DEVELOPMENT REVIEW BOARD
SUPPLEMENTAL SUBMITTAL

PROJECT NO. PR-2021-006238

Application No. SI-2021-01916

Re: Allaso Louisiana Site Plan – DRB Comment Responses (PR-2021-006238)

SHEET NO
SDP5.1

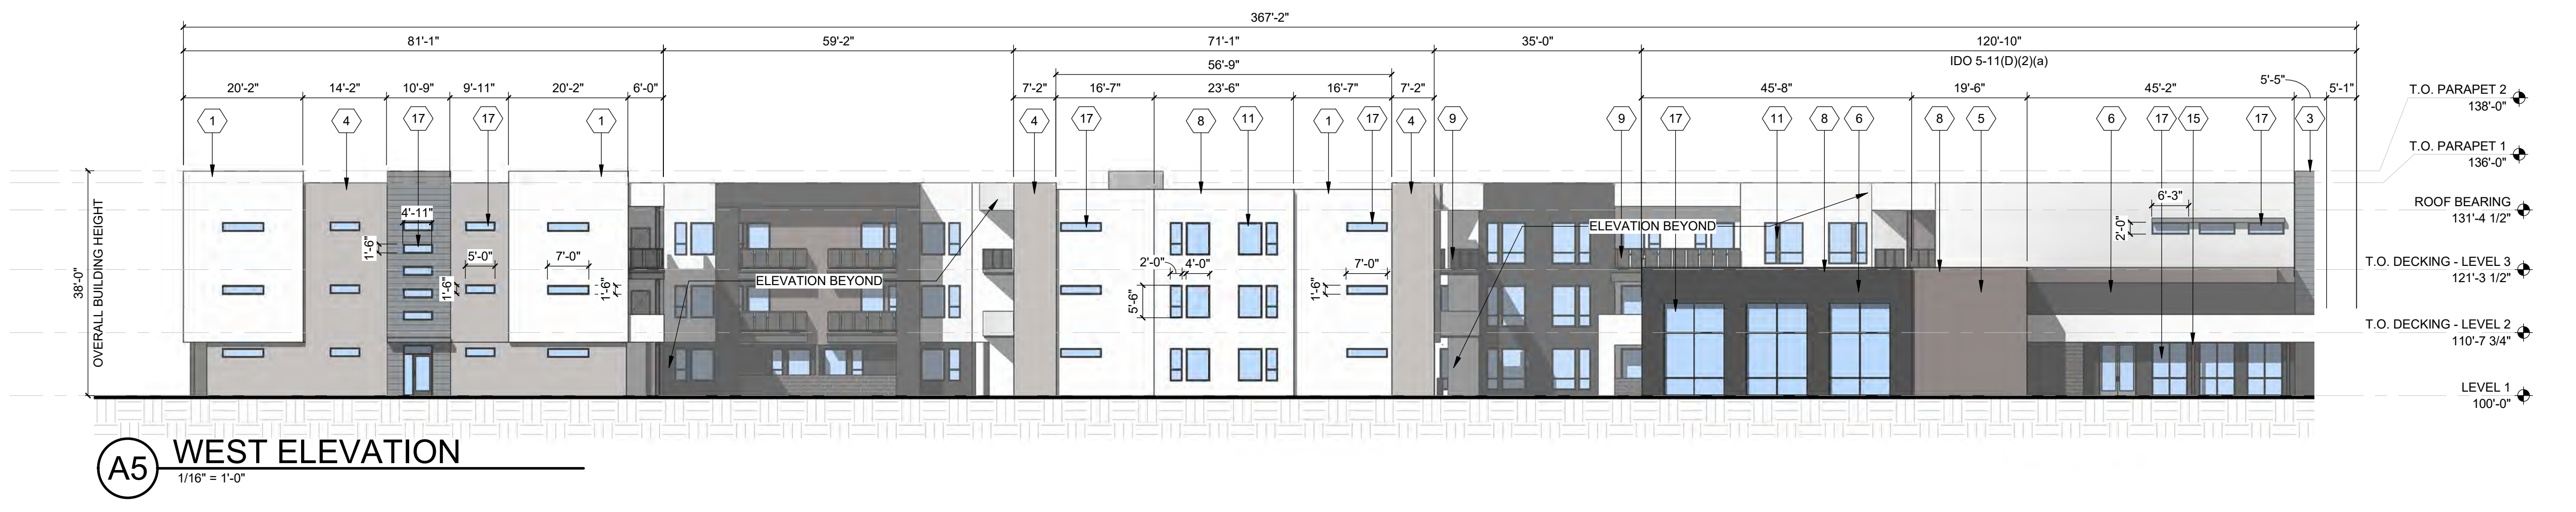
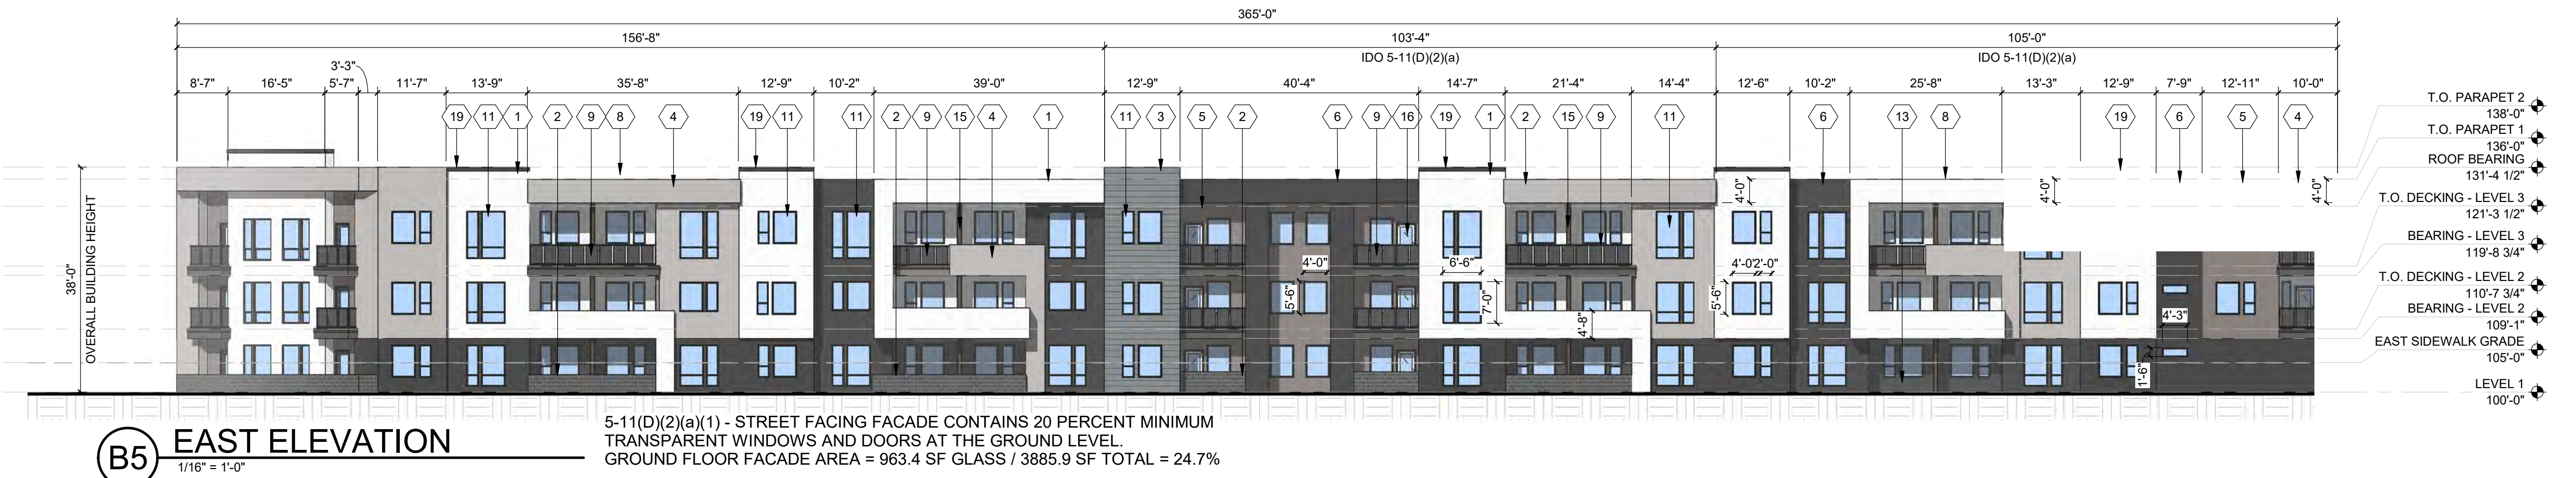
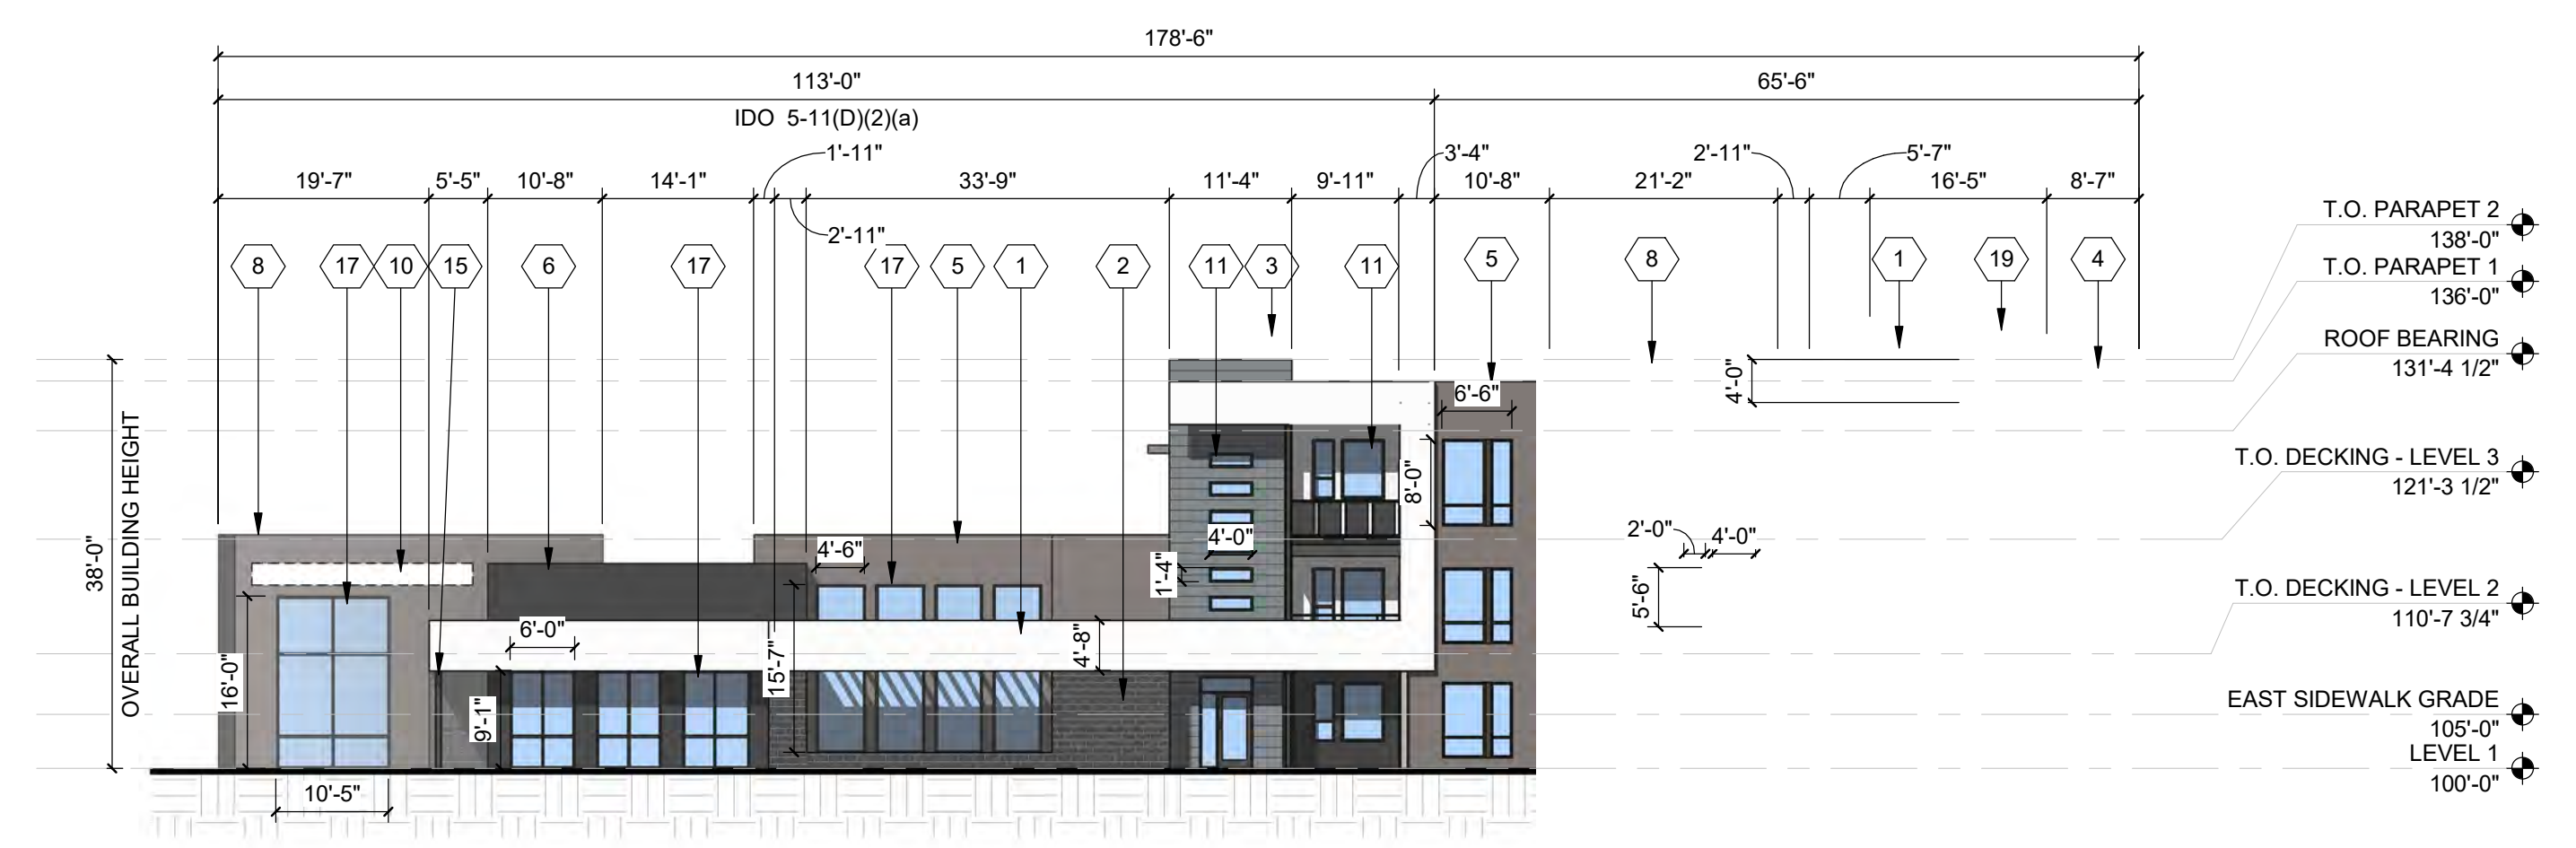
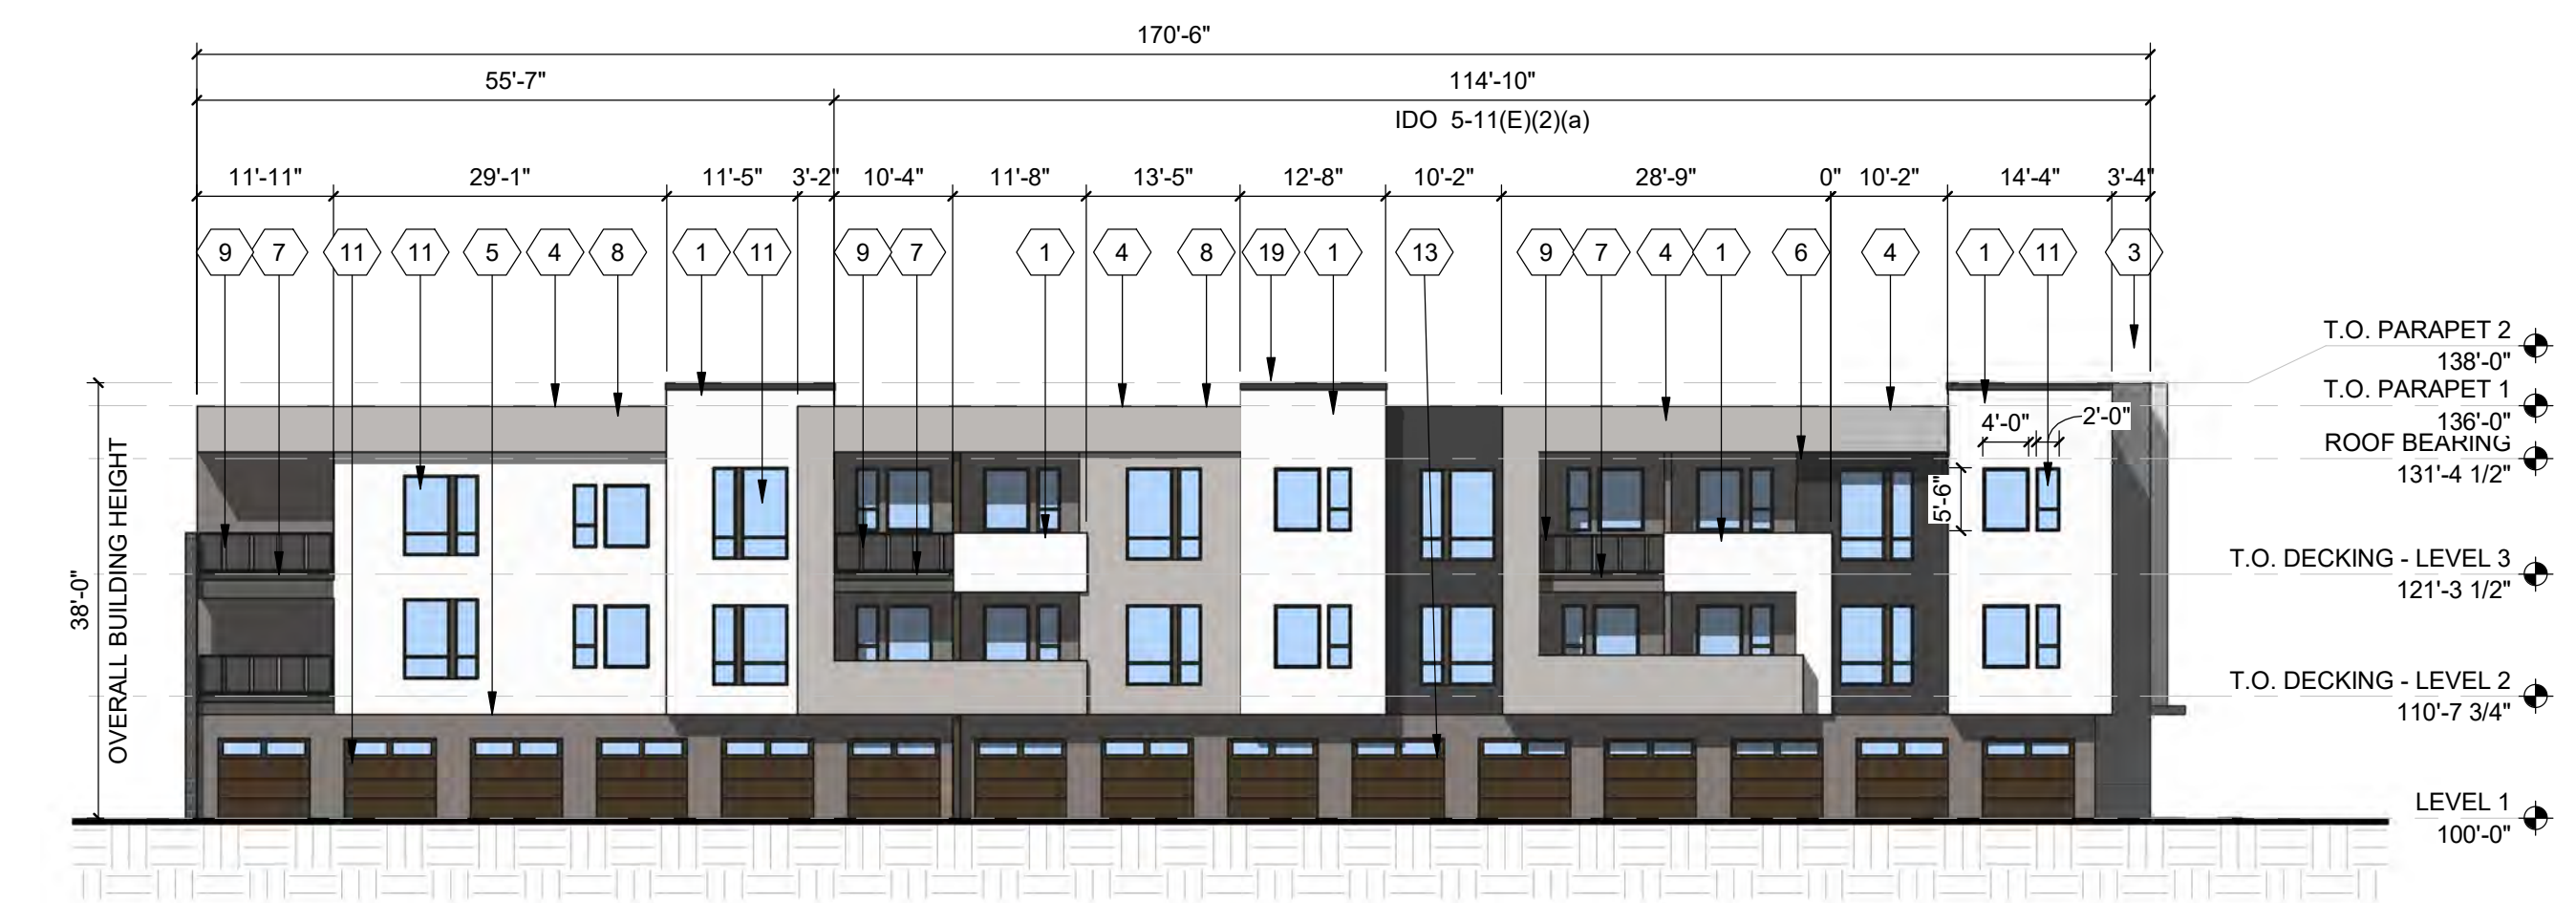
10. The building facades must meet 5-11(D) of the IDO. Provide a comment response letter explaining how the requirements of 5-11(D) are being met.
 - a. **A note has been added to the elevations demonstrating compliance with the glazing requirements for the street-facing facades. IDO Section 5-11(D) Multi-family Residential Development is met in the following ways:**

- 1. Building entrances are emphasized by contemporary architectural overhangs.**
- 2a. The facade design incorporates elements of human scale by incorporating windows that make up 20% of the ground floor of street-facing facades (see calculations on south and east elevations) and are recessed 2 inches on upper floors. Windows facing west have been reduced in size to reduce heat impact or are shaded by balcony structure above or incorporate sunshade devices where needed.**

- 2b. Facade articulation is achieved in combination of recesses and projections every 30 feet minimum (see dimensions on elevations for plane changes), more than one finish material or color is used on every facade (refer to exterior finish legend indicating up to 6 color and material selections), and balconies are incorporated at every dwelling unit for visual interest.**

- 3. Facade length exceeds 60 feet; therefore, roofline extends from 36'-0" to 38'-0" at intervals less than 60 feet continuously.**
- 4. 5-11(D)4 is not applicable.**

D1 WEST ELEVATION - BUILDING A - MAY 21 9AM
3/64" = 1'-0"

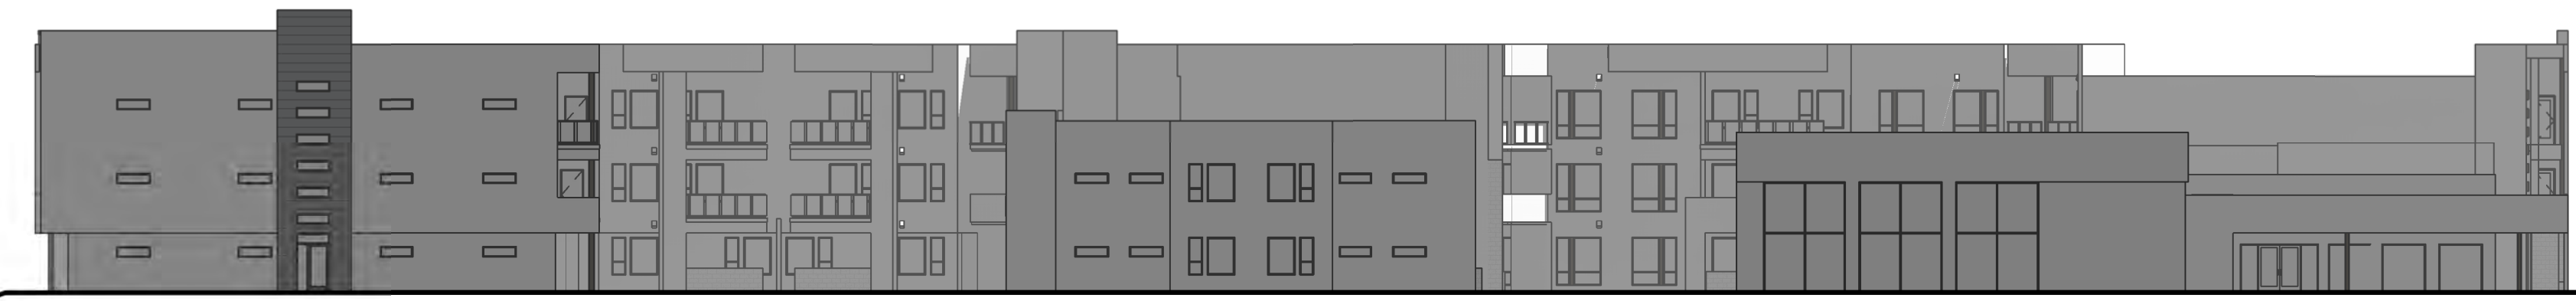
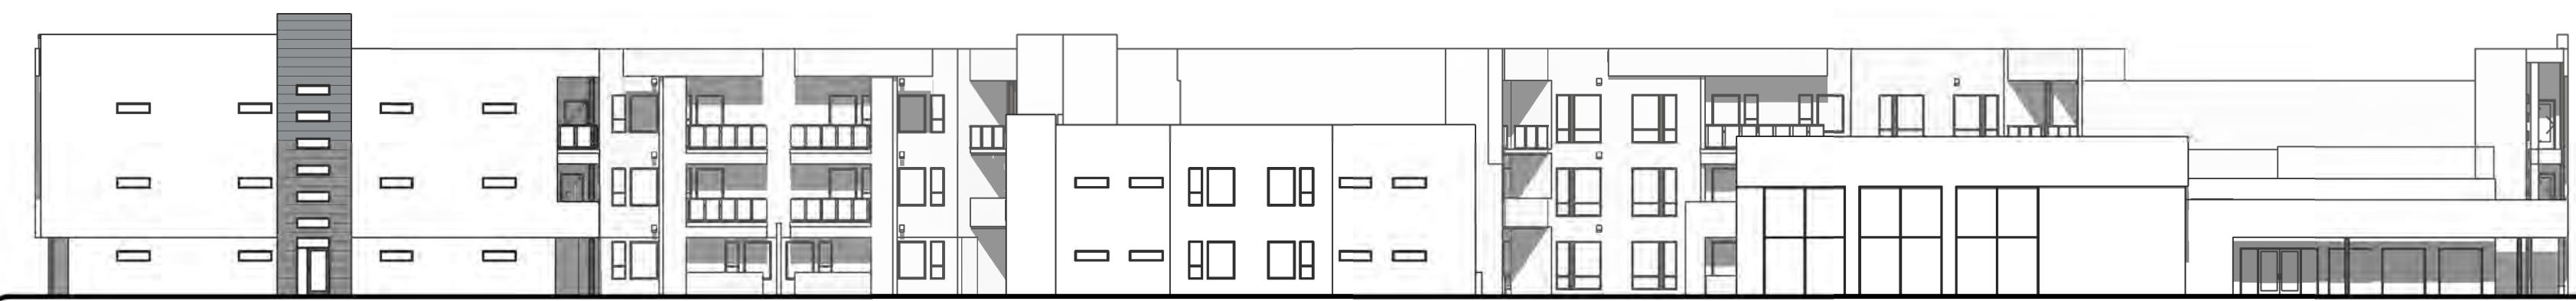
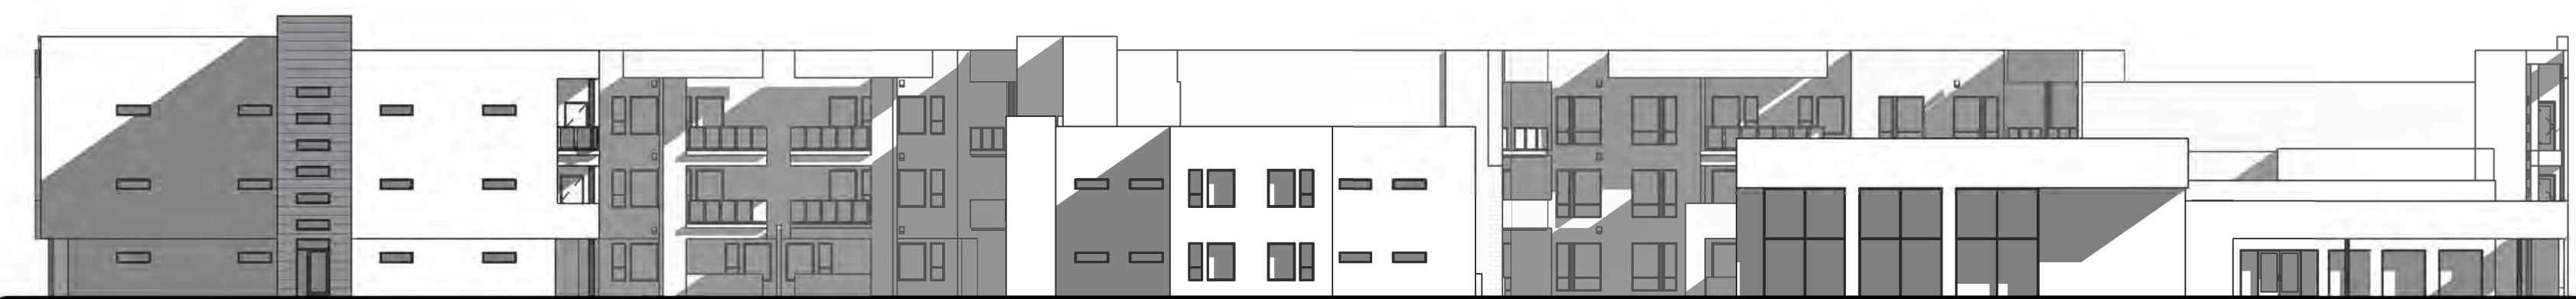
11. There is no sun/shade analysis for this submittal. Please provide as part of your plan sheets. See the detail on Page 3 of the Climatic and Geographic Building design requirements.
 - a. The sun/shade analysis has been resubmitted as the last few sheets of the plan set.**
12. These are preliminary Planning comments, and there could be additional and/or revised Planning comments on this application.
